Reigning Hope, PPR-19-035

Please accept the following comments from El Paso County Public Health regarding the project referenced above:

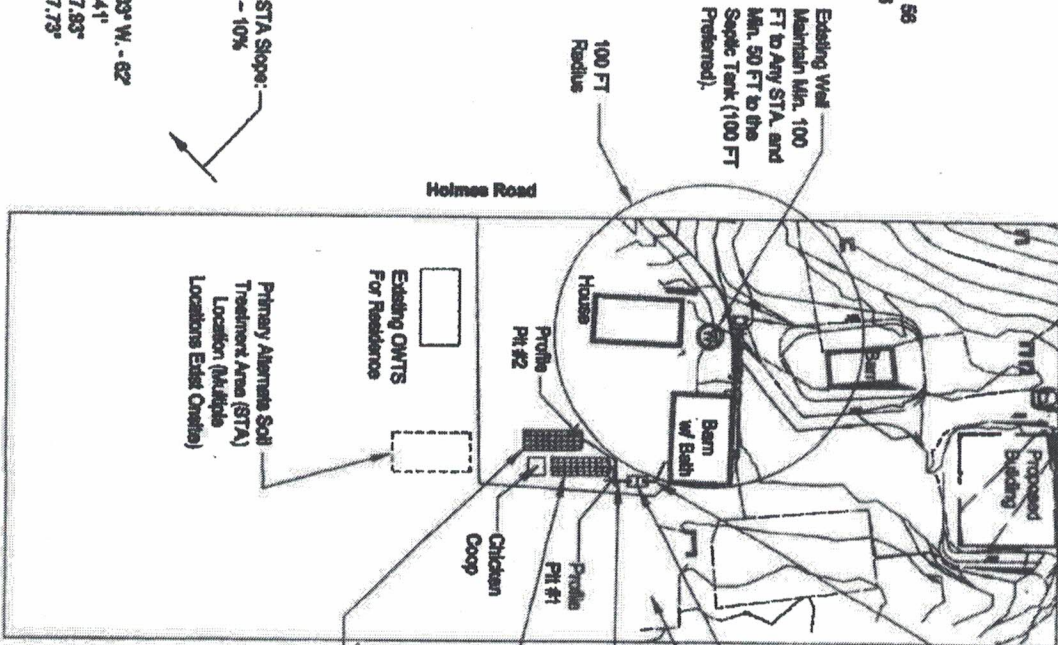
- **All components of the two OWTS's and an additional secondary soil treatment area for each OWTS are required to be protected from compaction by vehicular traffic and livestock. Fencing and/or landscaping are examples of soil treatment area protection methods.**
